TO:	Helen Donaldson, Sr. Planner	DATE:	12/6/2018
FROM:	Michael Guethle, PE; Ryan Wingard, PE	PROJECT NO.:	13982C
SUBJECT:	Gilman St. - 22; MMC Parking Building (PL-000331-2018)

Wright-Pierce has reviewed the Level III Site Plan Application information provided for the Congress Street Patient Care Building proposed at 22 Gilman Street. The project will include redeveloping an existing parking garage into 64 modern patient rooms and 19 procedure rooms.

12/17/2018
C11-01

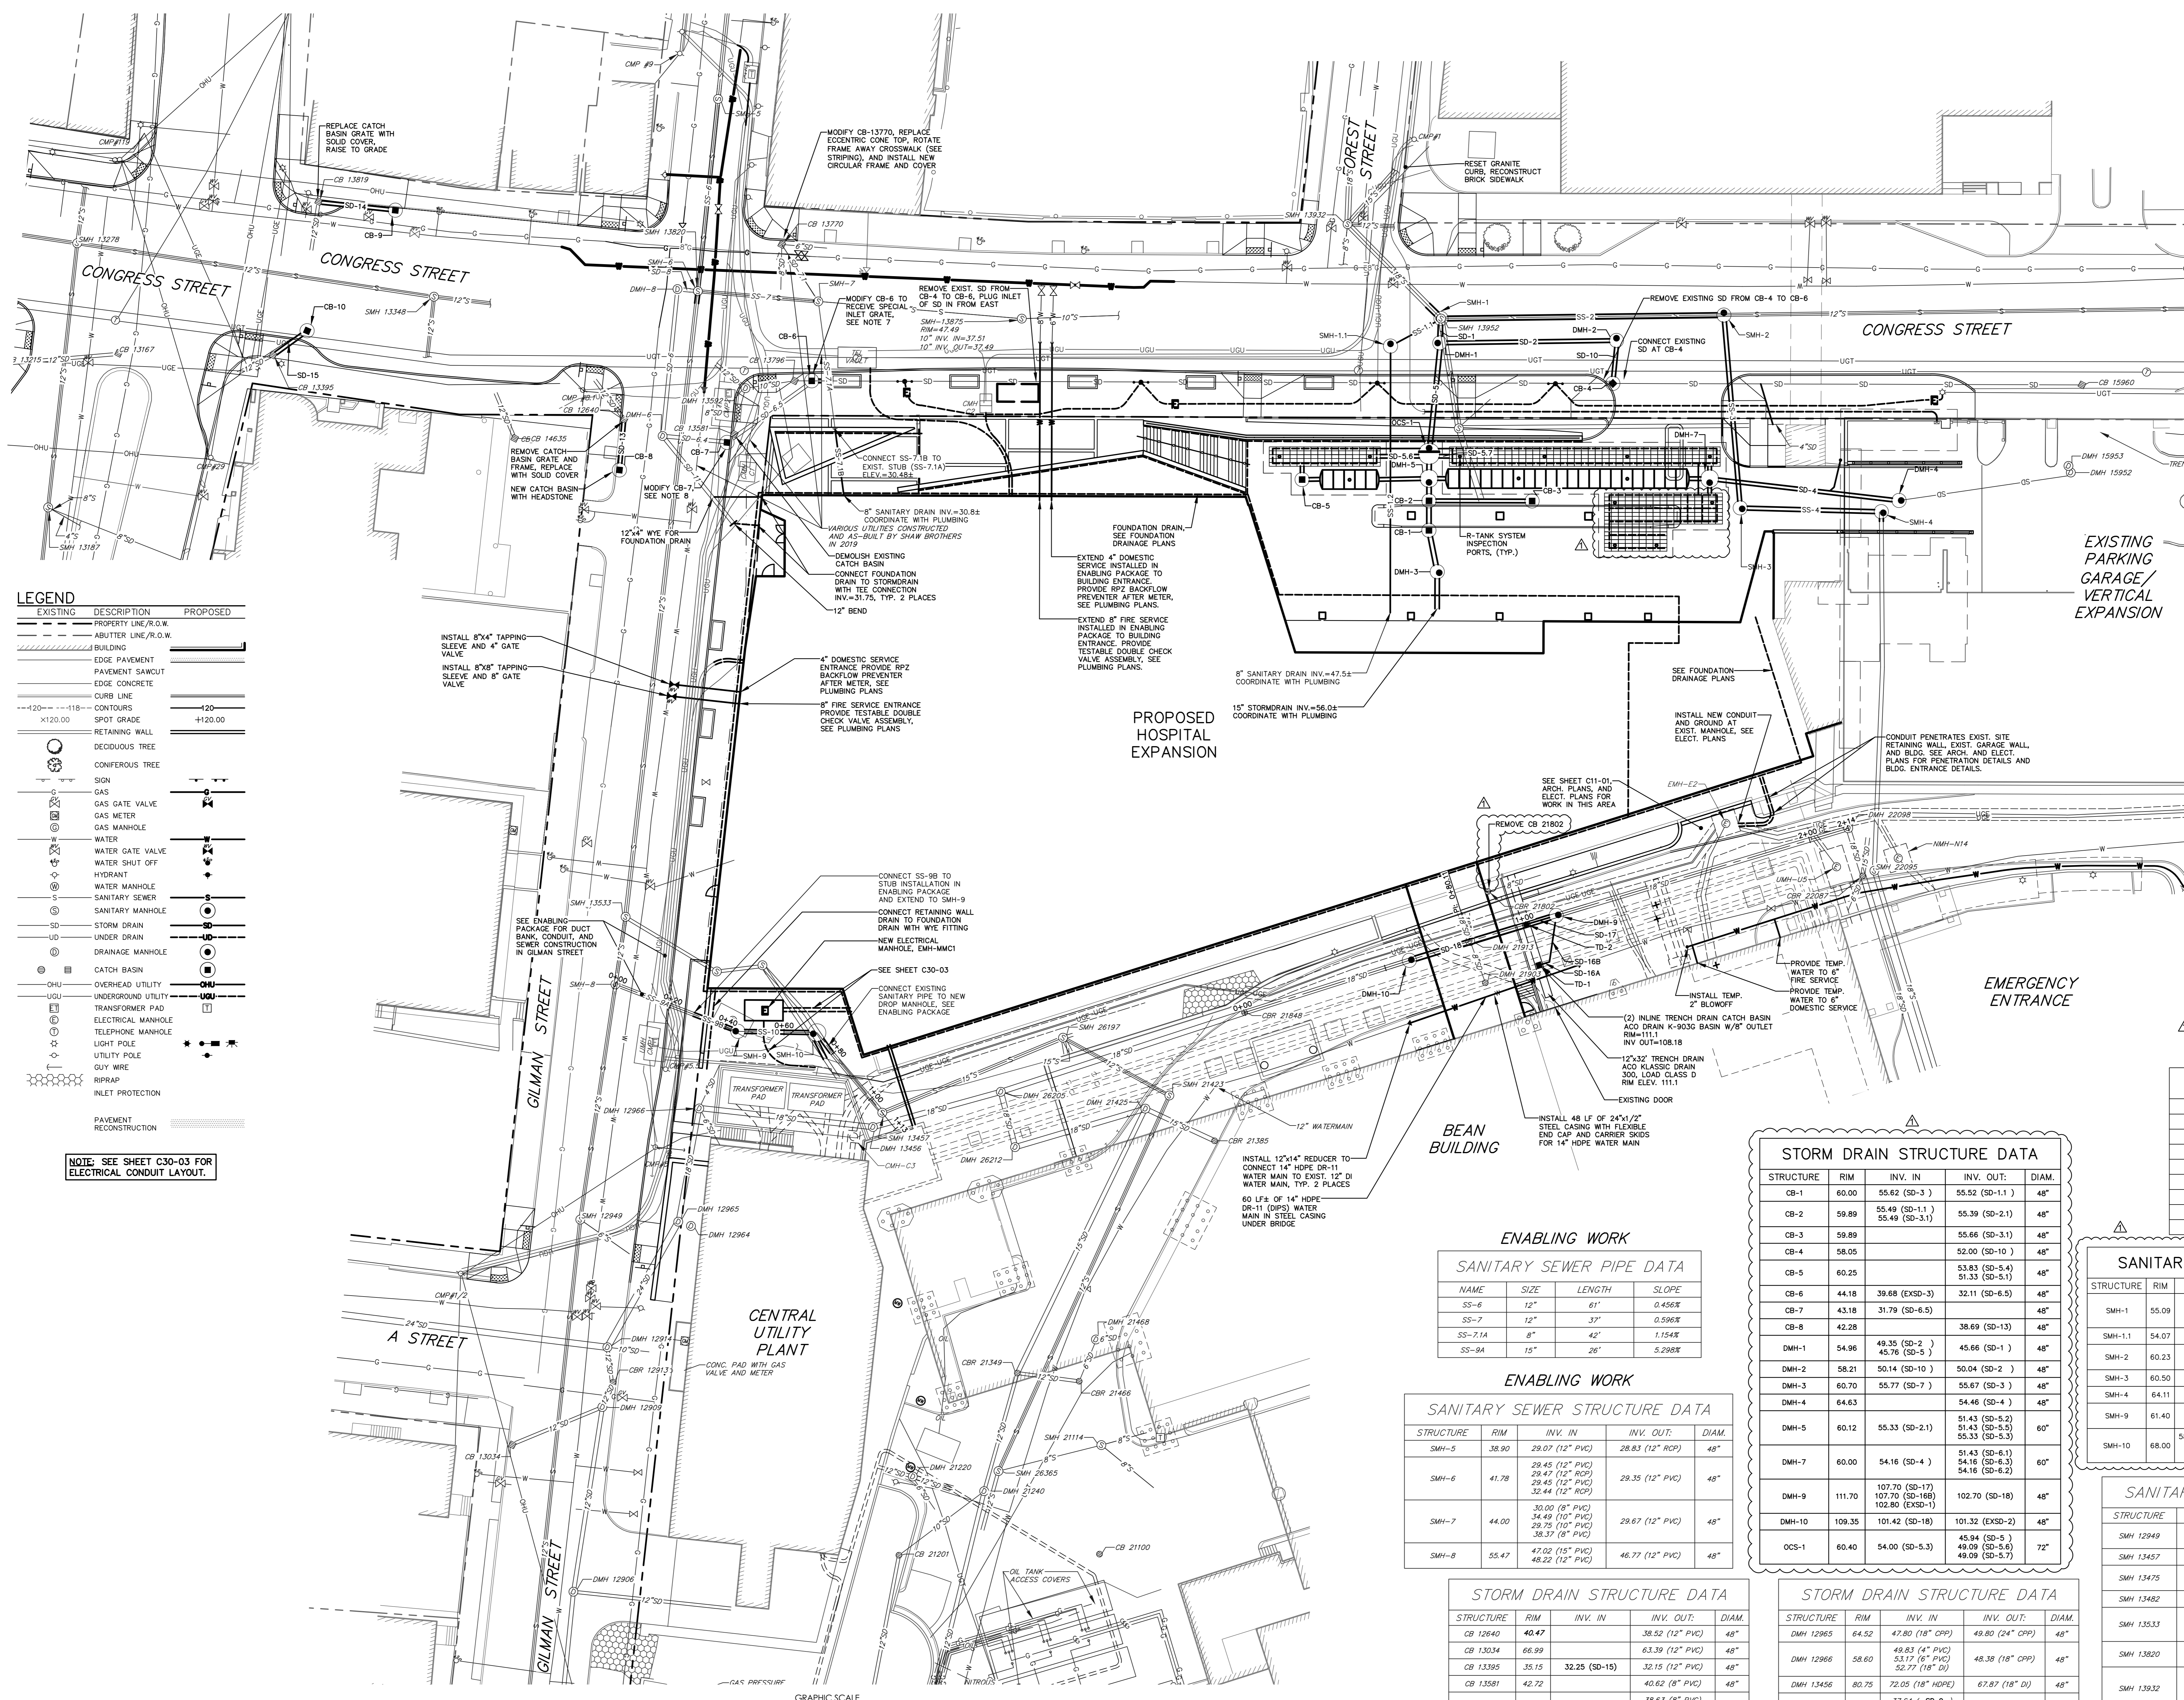
- a. Additional information has been provided on Sheet C30-01, C11-01, C40-01, and C30-04 to indicate site grading and pipe information. The following shall be clarified:

- i. SD-2 pipe references have been qualified with two separate pipes; Pipe SD-2 and SD- 2.1. No further action necessary.
 - ii. SD-3 pipe size has been confirmed to be 15". No further action necessary.

- iii. Data provided in the project pipe tables have been modified so that pipe slopes generally match slopes as calculated from the invert and length data. No further action necessary.

- b. The applicant has provided additional information regarding sewer details on Sheet C11-01 and Sheet C30-03. No further action necessary.
- c. The applicant has indicated that capacity to serve letters from utilities will be provided as they become available. This may be considered a condition of approval for the project.

-Sheet C-11: CB 13370 (NE Corner) and CB 12640 (SW corner) are existing basins that are located in proposed crosswalks. If these structures have eccentric cones, rotate them so they are outside of the crosswalk.

-Sheet C-11: SD-16 callout is obstructed or missing, and should be included on the construction plans.

-Sheet C-11: Existing Storm Drain Structure Data table shall be updated to include inlet from Pipe SD-13

-Sheet C-11: Existing CB 13395 rim/frame/cover should be reviewed: Other CBs located in sidewalks are being raised and converted to Drainage Manholes (DMHs). Applicant shall confirm if this structure is to remain a CB or a DMH.

-Sheet C-11: There appear to be conflicts at the existing storm drain and proposed tree wells. Applicant shall provide solution to minimize future root intrusion from trees, or relocate storm drain.

-Sheet C-11: There appear to be conflicts with underground utilities at several structures and pipes. Applicant shall provide additional information for location of proposed utilities at the following pipes and structures:

Storm Drain 9

Sanitary Sewer 9

Catch Basin 7

Catch Basin 10

TITLE
DETAILS
STORMWATER SYSTEM
CONGRESS STREET
EXPANSION

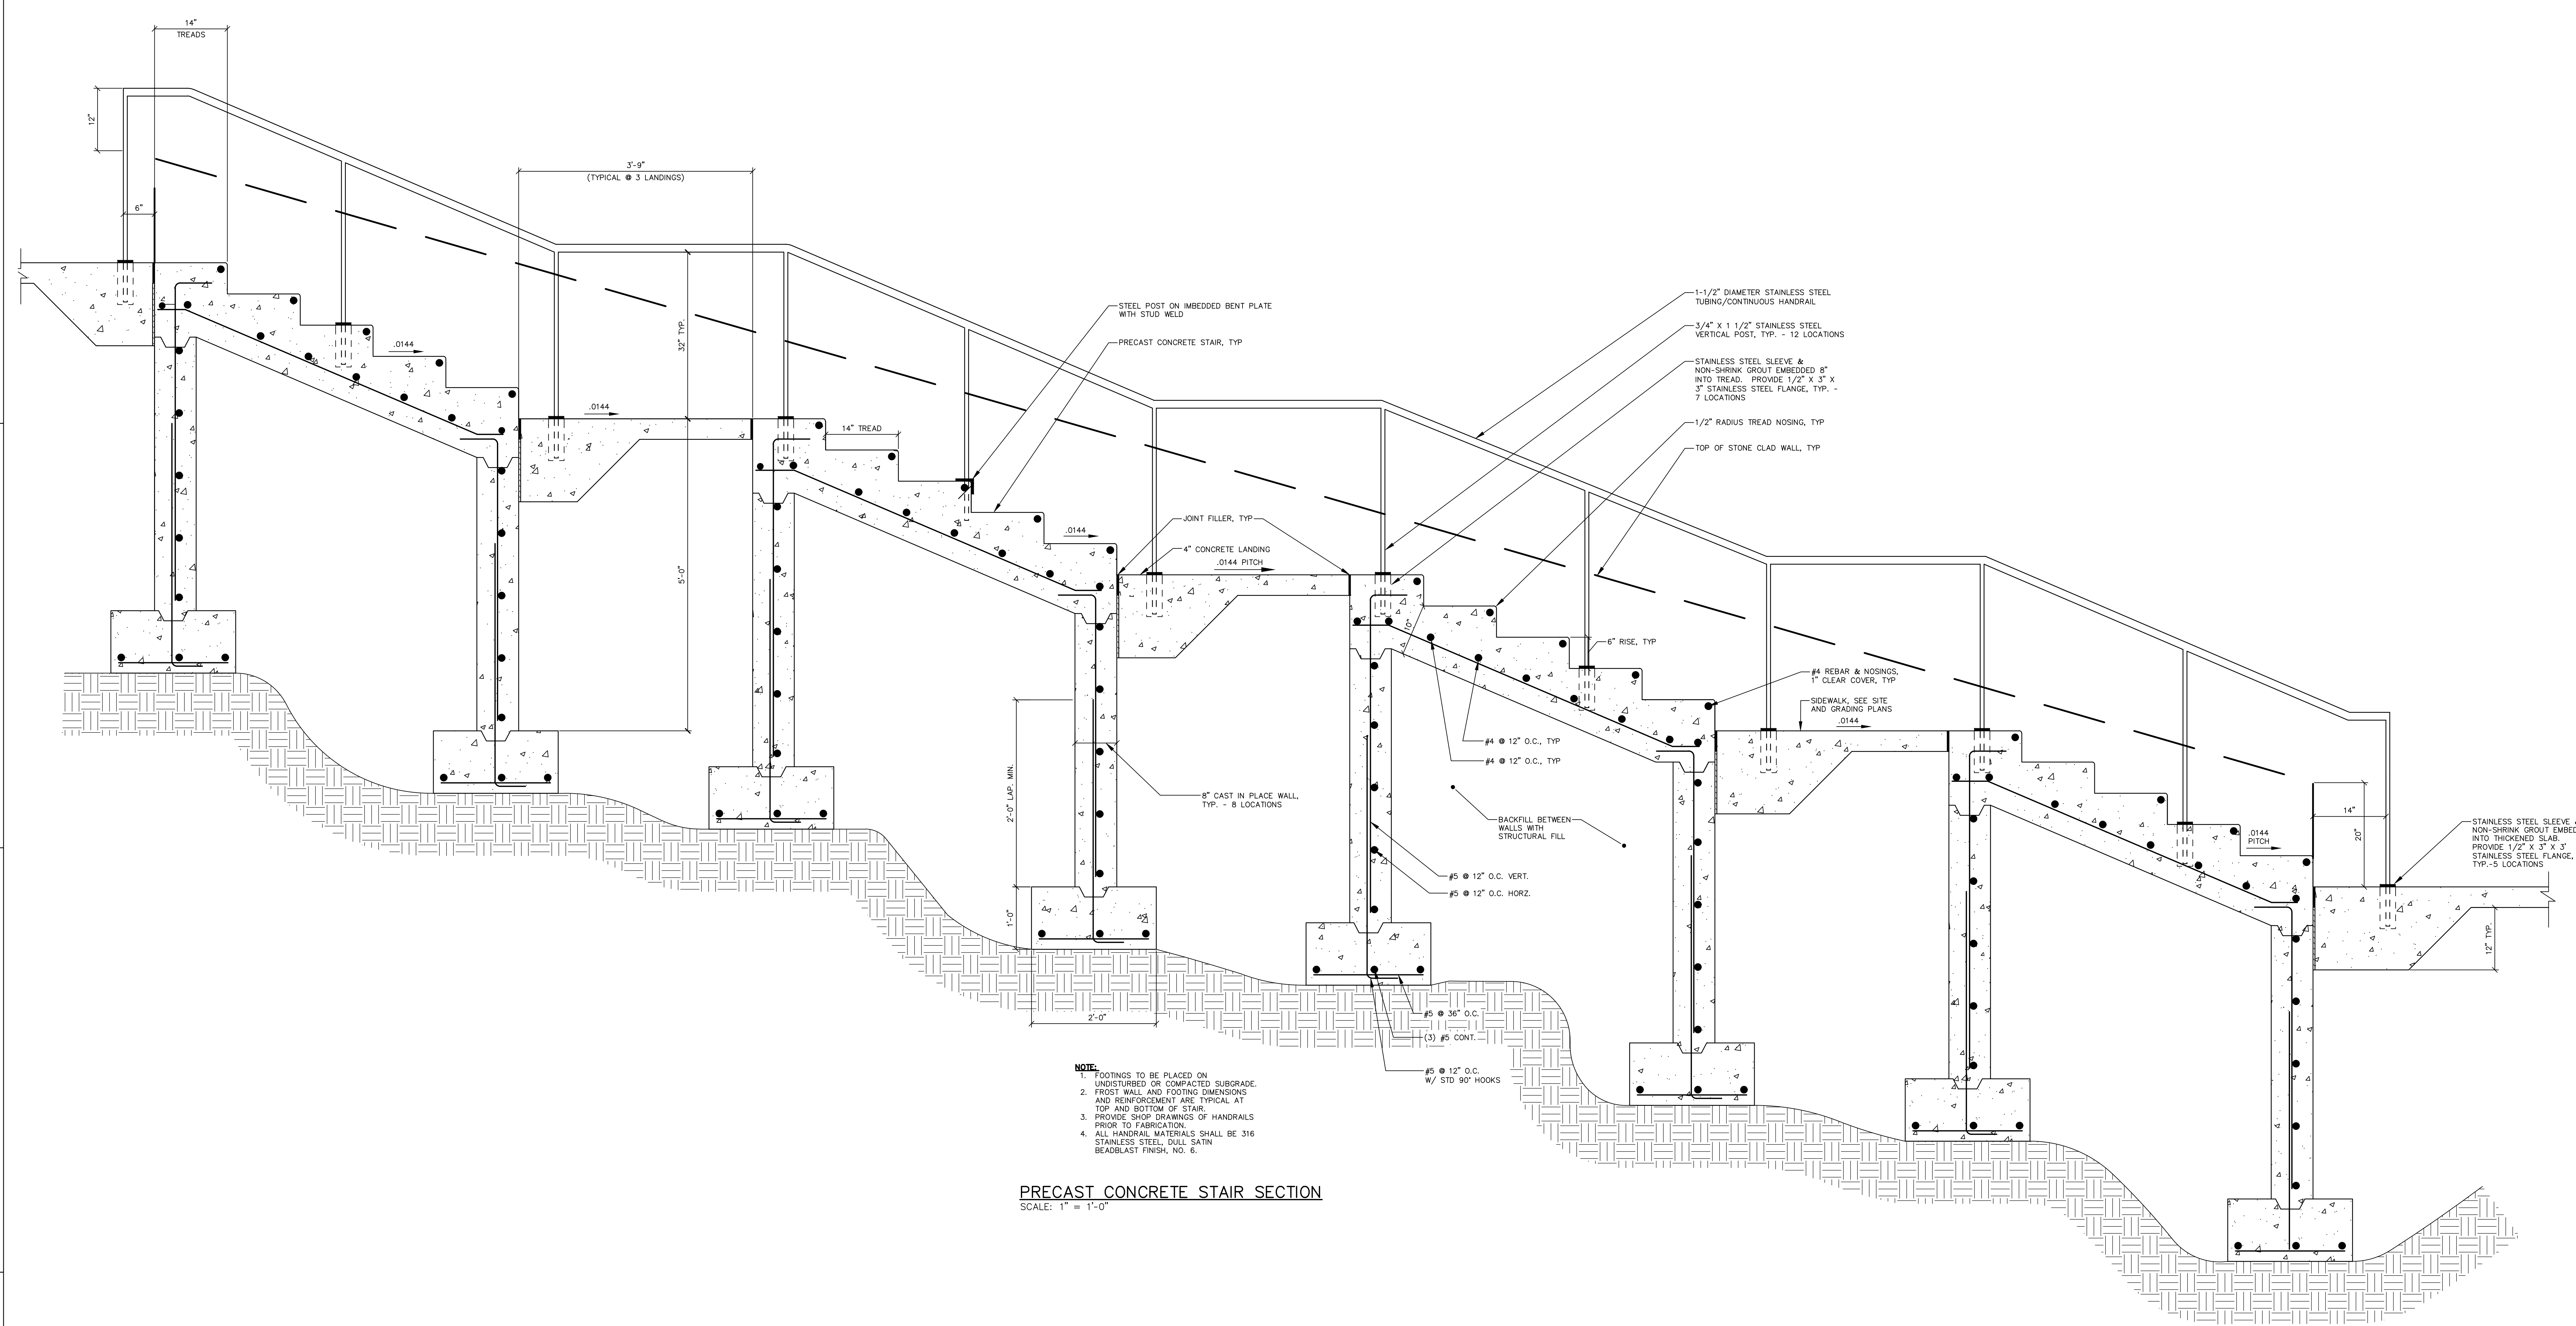
- b. Isolator row detail on C30-04 pipe size has been increased to 24", and the applicant has confirmed that a 12" or greater pipe is large enough facilitate maintenance/cleaning access to the isolator row. No further action necessary.
